HATCH END OLD POULTRY FARM, MIDDLE ASTON ROAD, MIDDLE ASTON: DEMOLITION OF EXISTING BUILDINGS. ERECTION OF REPLACEMENT BUSINESS UNITS, ANCILLARY HUB AND ASSOCIATED EXTERNAL WORKS.

20/01127/F

Steeple Aston Parish Council held a virtual meeting on June 15th 2020 at which this application was discussed at length. The meeting was attended by a large number of members of the public who all spoke against the application. The Parish Council wishes to **OBJECT** to this application for the following reasons:

1 Proposed Street (East) Elevation  
Scale: 1:200

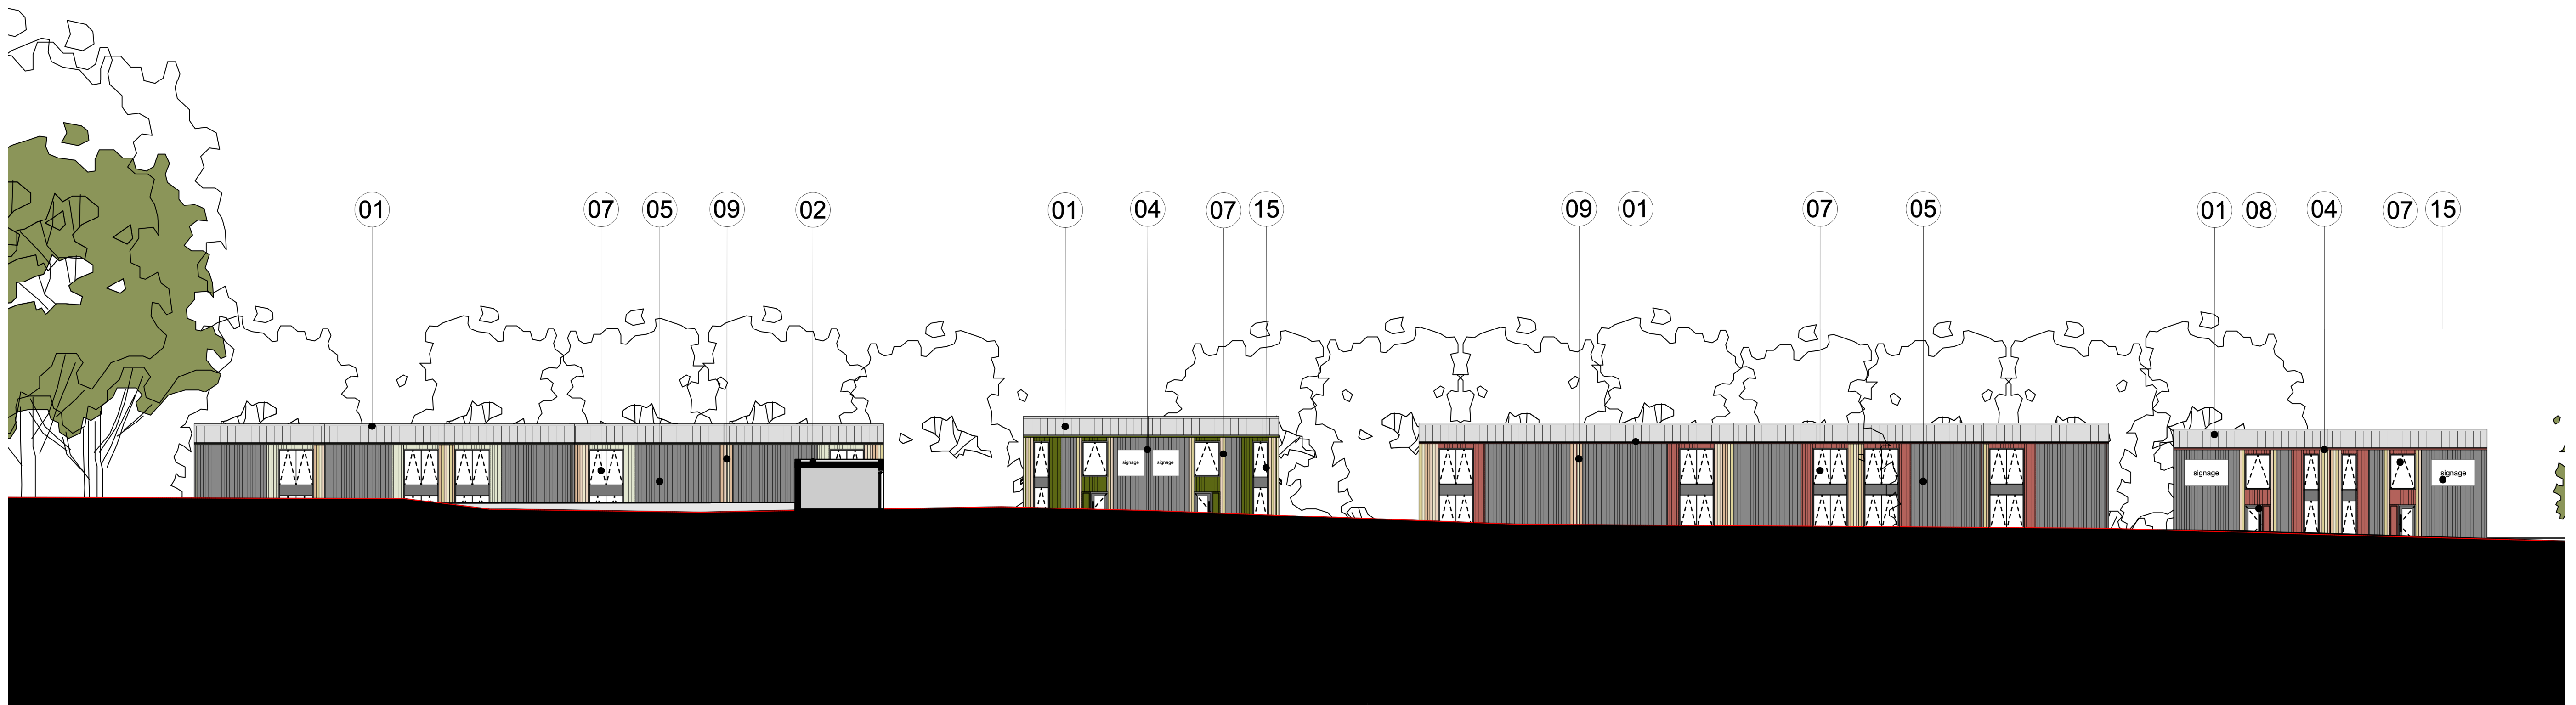
The proposed new buildings are significantly taller than the existing single-storey sheds that they replace. Their form, materials and massing are all inappropriate for a rural site and do not even satisfy the applicants' own criteria of creating an agricultural appearance. This is a business park that will look like many other business parks. It is of inappropriate appearance for its rural location, and endangers the importance of the continuing visual separation of the two villages of Middle and Steeple Aston because of its urbanising effect.
